2 October 2020
Our Ref: 20618A.25PS_RTS letter

RE: SSD-9483 UPGRADES TO CHATSWOOD PUBLIC SCHOOL AND CHATSWOOD HIGH SCHOOL

drawing	
Building G - Elevations	
scale	1 : 250@A1
drawn	LDC
checked	LDC
project no	180326.00
drawing no. DA-BG-A2002	
issue	
C

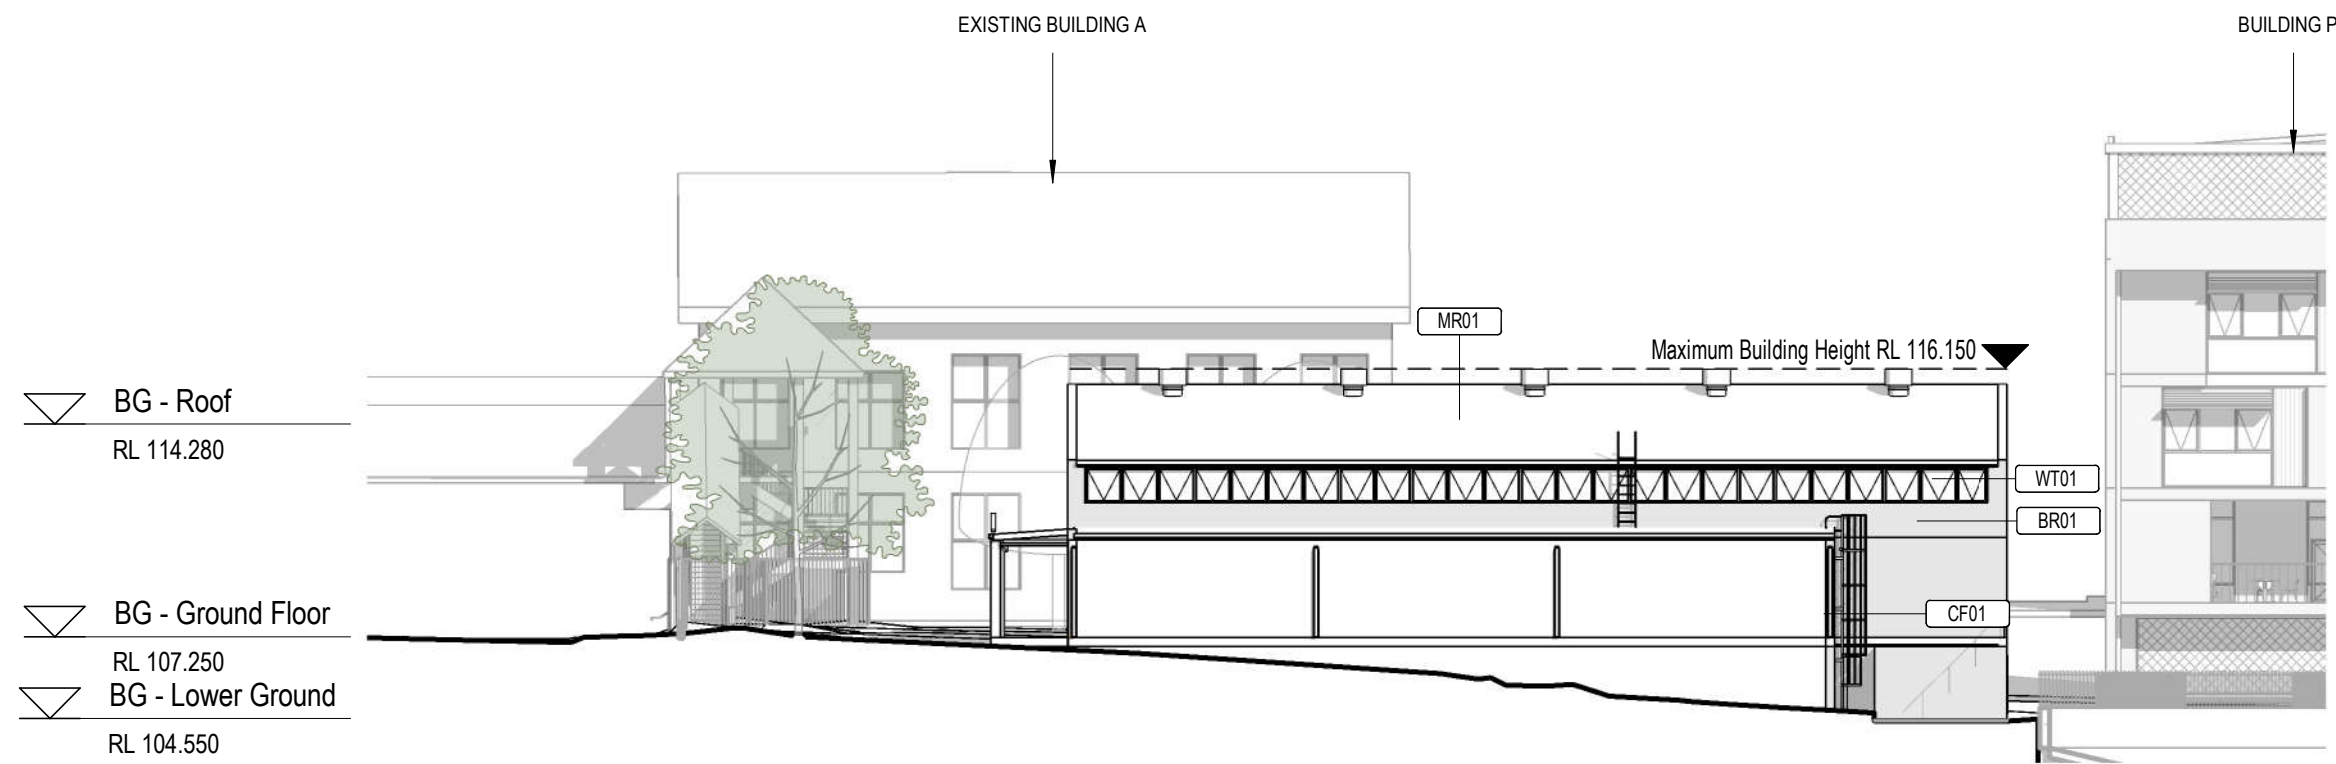
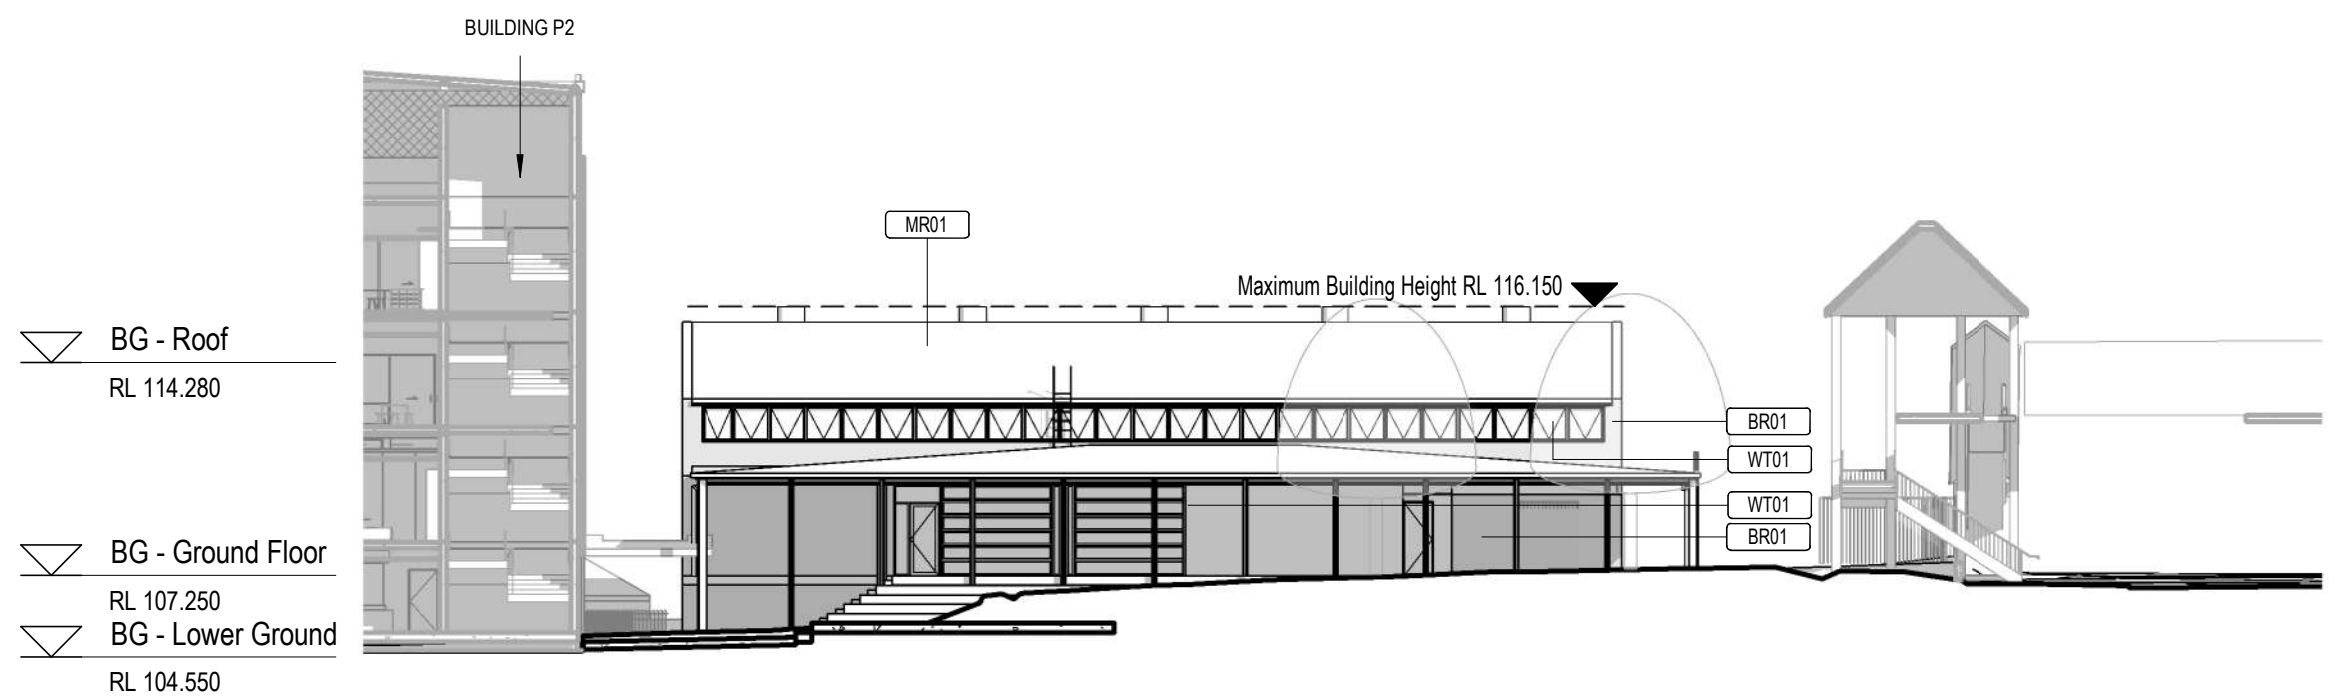
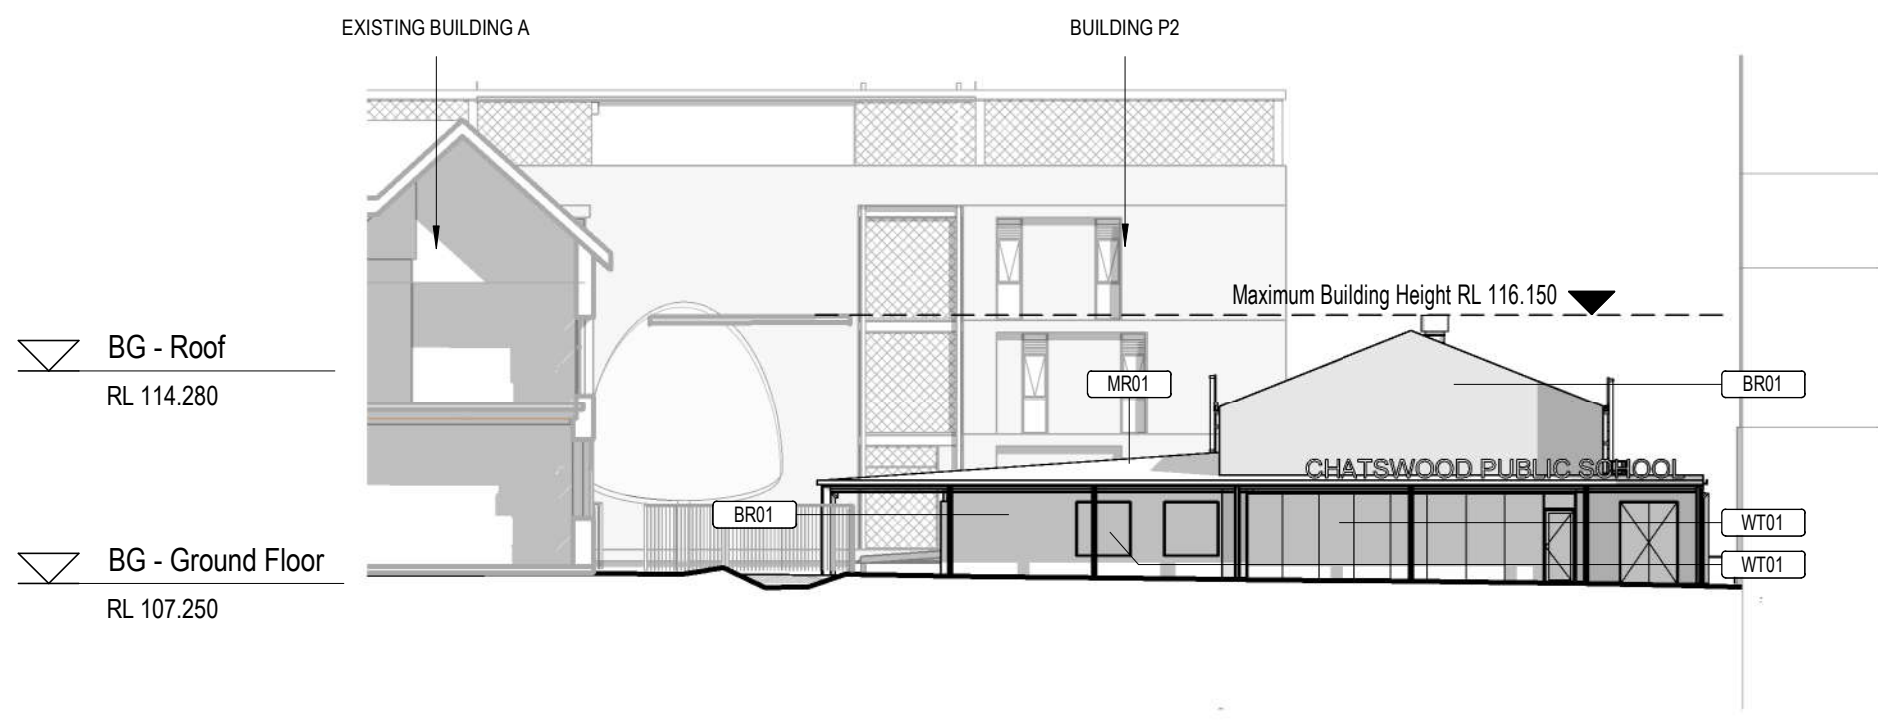
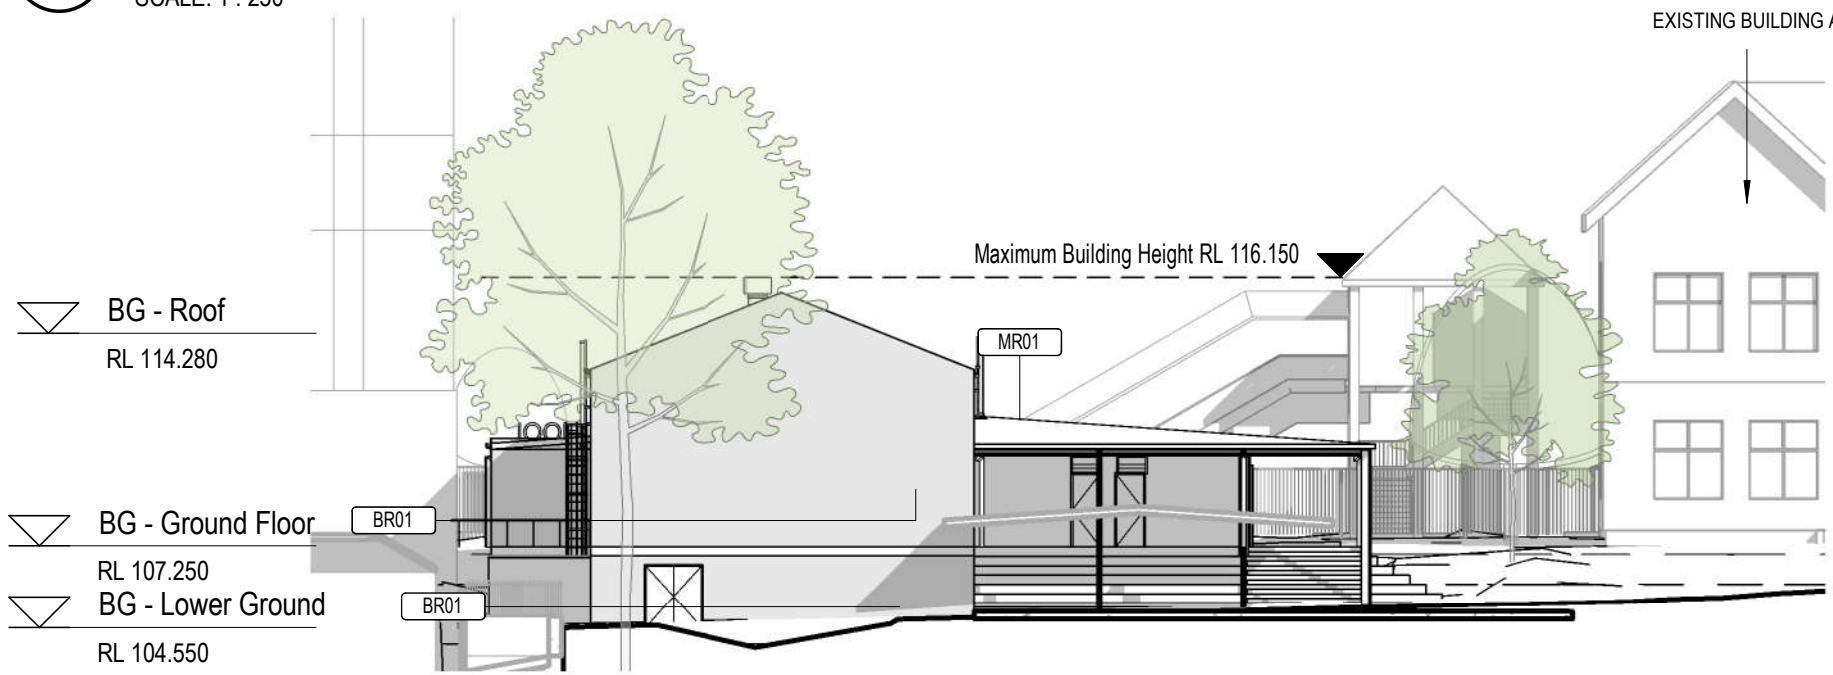
Concern was raised by DPIE in regard to the proposed 0m side setback to the northern boundary, where it adjoins the residential property at 1 James Street particularly in relation to overbearing built form with poor outlook from within the private open space of that property.

- Increase setback at the north-west corner of Building G to James Street neighbour;
- Provide overall boundary setback of 1m to the northern boundary;
- Relocated and consolidated bathrooms in the southern part of the plan; and
- Fence and gate added for maintenance.

1 Elevation East P1
SCALE: 1 : 250

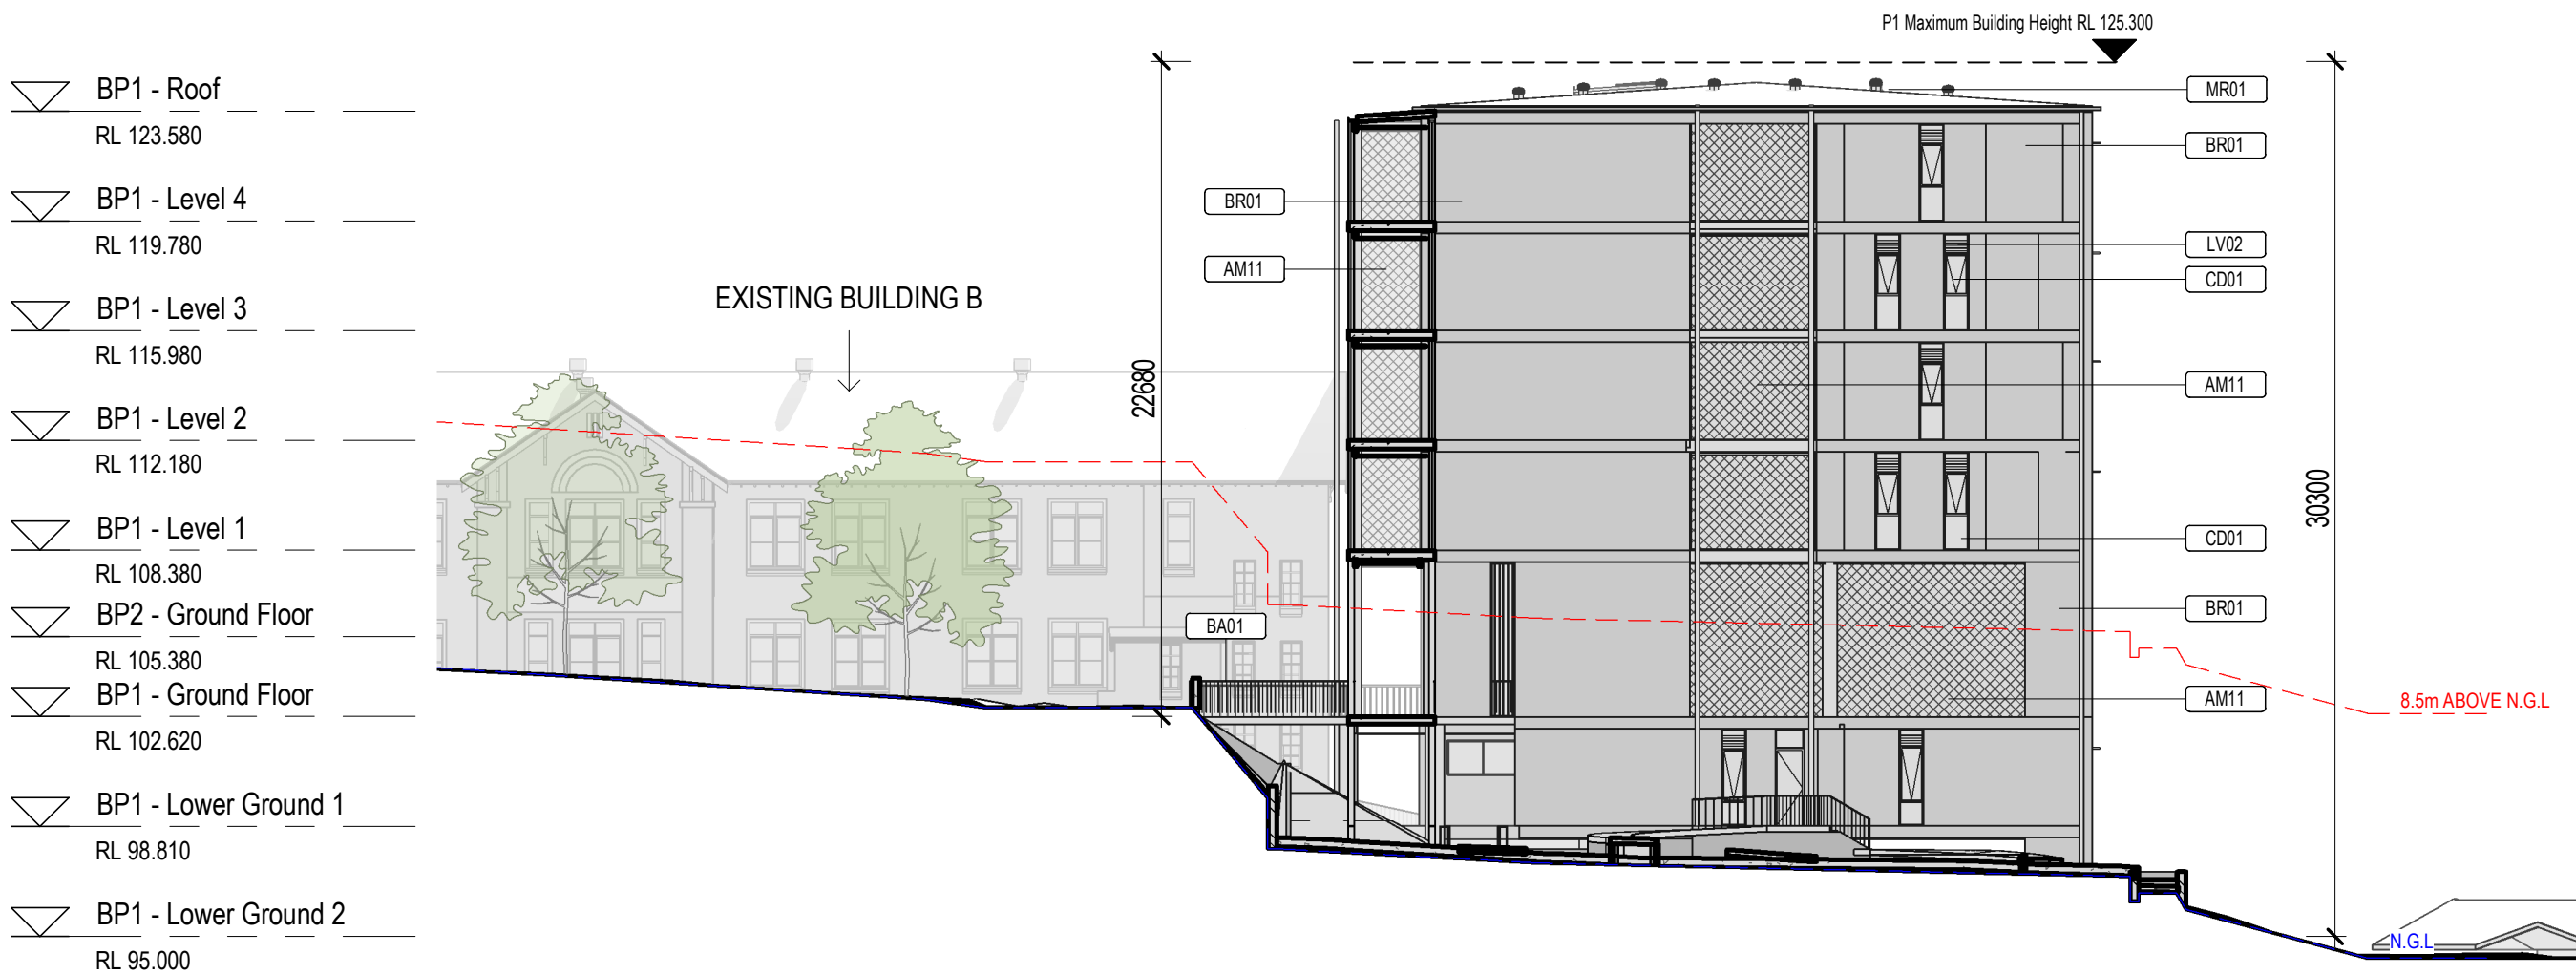
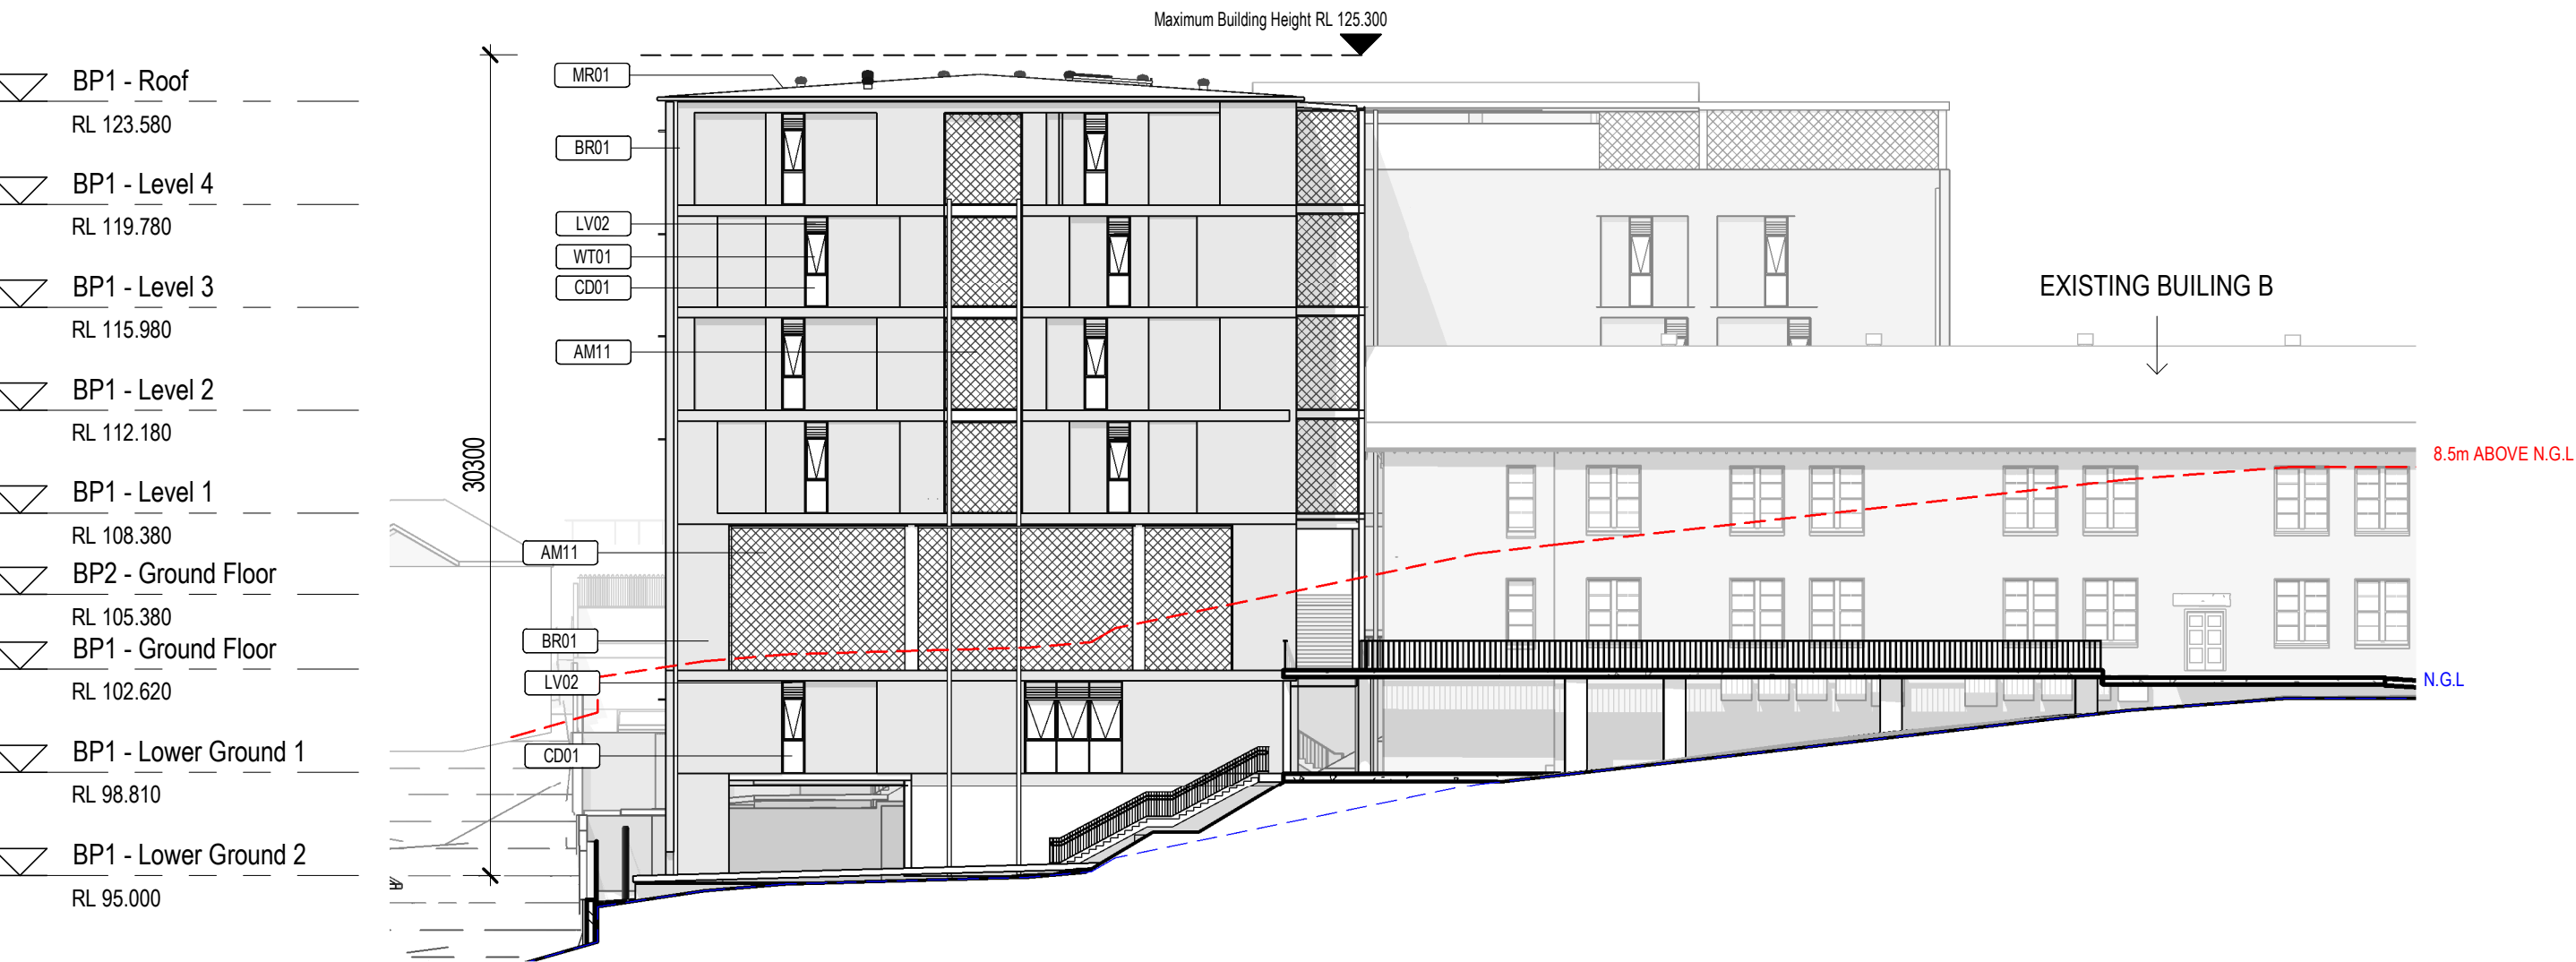
Public submissions raised concern about the height, bulk and scale of building P1, and DPIE raised a range of specific concerns including:

- Amenity impacts of the building on the low scale dwellings at No. 1 and No. 3 Jenkins Street and 2 James Street; and
- Excessive height for this part of the site given wall height, setbacks, shared boundaries, topography of the site and topography of adjoining sites.

- Materiality has been selected having careful consideration of the City and Heritage contexts of the site;
- Materiality will create a design link between the PS and HS sites;
- Glazing is maximised on the northern and southern facades, and is minimised on the western façade;
- A review of horizontal and vertical options for articulation of the northern and western elevations has been carried out and amendments have been made without reducing play space;
- Cut-outs within the external brick work have been used to provide additional relief; and
- Landscaping has been introduced to the outdoor area for screening to assist with outlook and privacy.

Additional design details of the western and northern facades of the building have been prepared to illustrate the light/shadow effects achieved through at various times of the day that will be viewed across the brick-work relief (refer **Figure 5**). This detail includes low-scale detailed sections of the typical brick recess and increased detail of the façade treatments.
